D Street Meeting with 189 St. John Street

Hi Nell – I met with Jeanne Handy and the following documents our discussion.

MMC ST. JOHN ST PG
PORTLAND, ME
ELECTRICAL SITE PLAN - 1

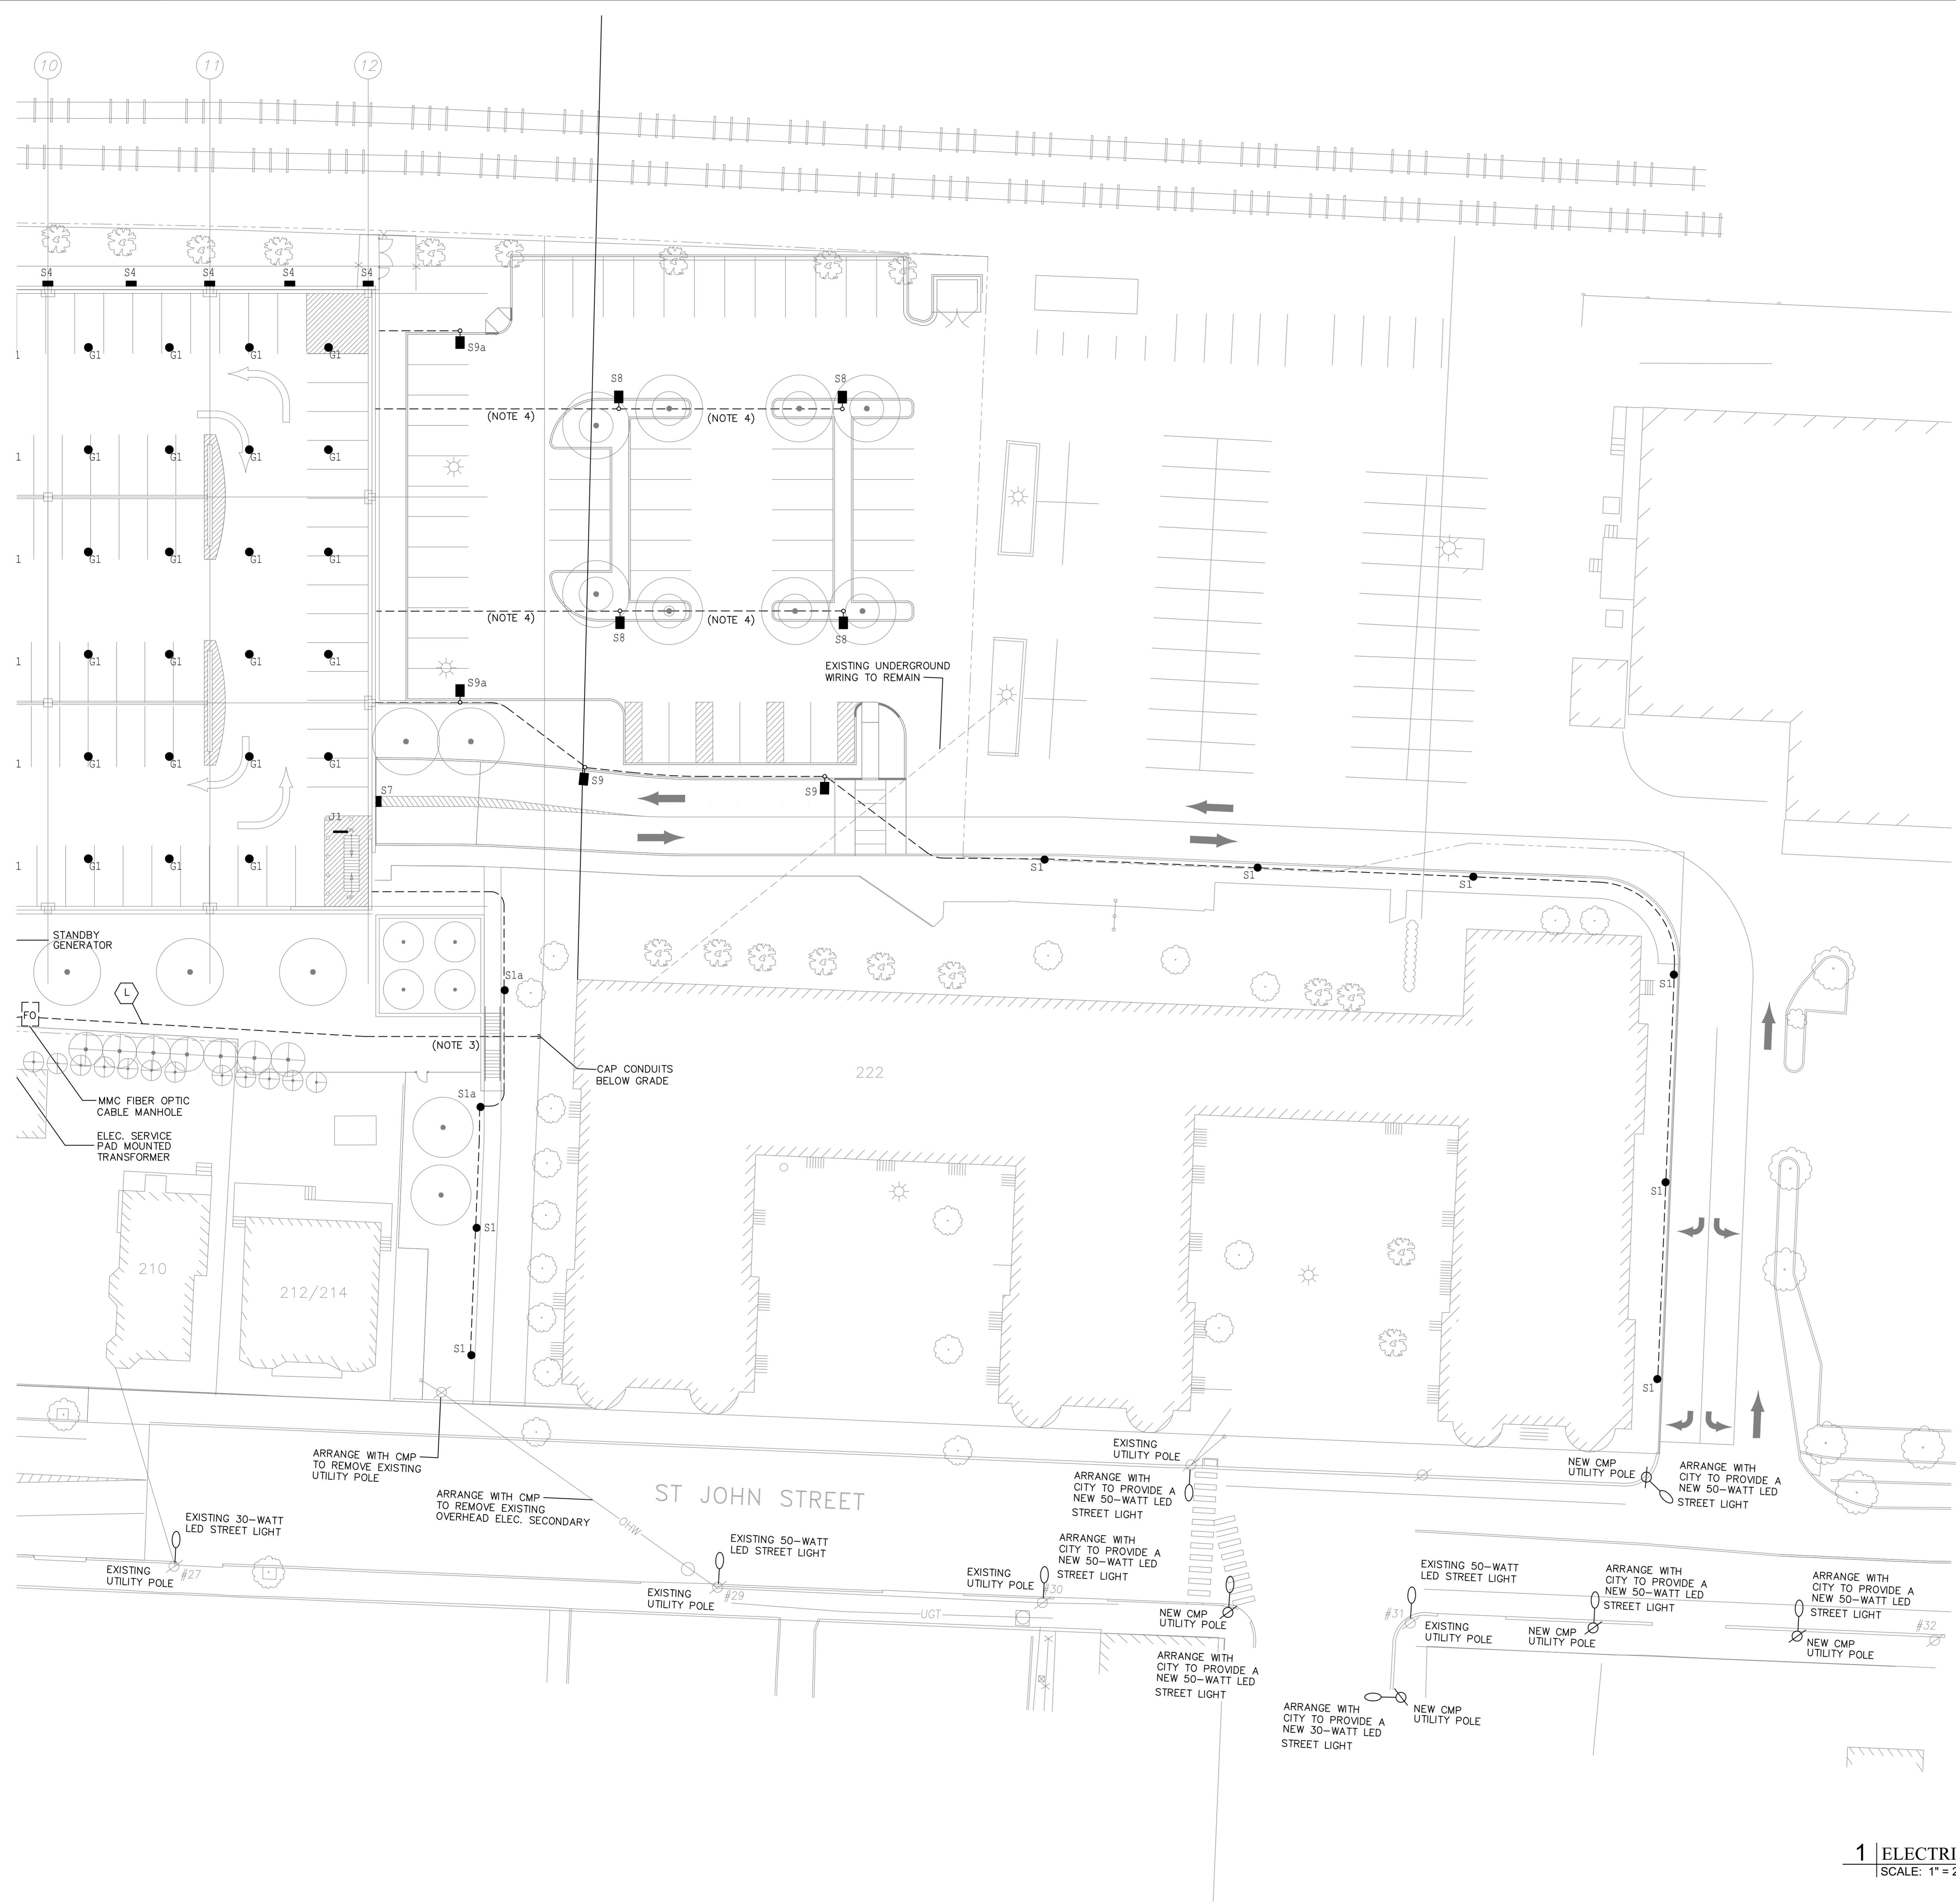
- I noticed a concrete step in the St. John ROW for her front entrance. It's not clear how that is changing or needs to change.
- There are two poles to be located in front of her house. A street light and a utility pole. She was interested in getting more detail.
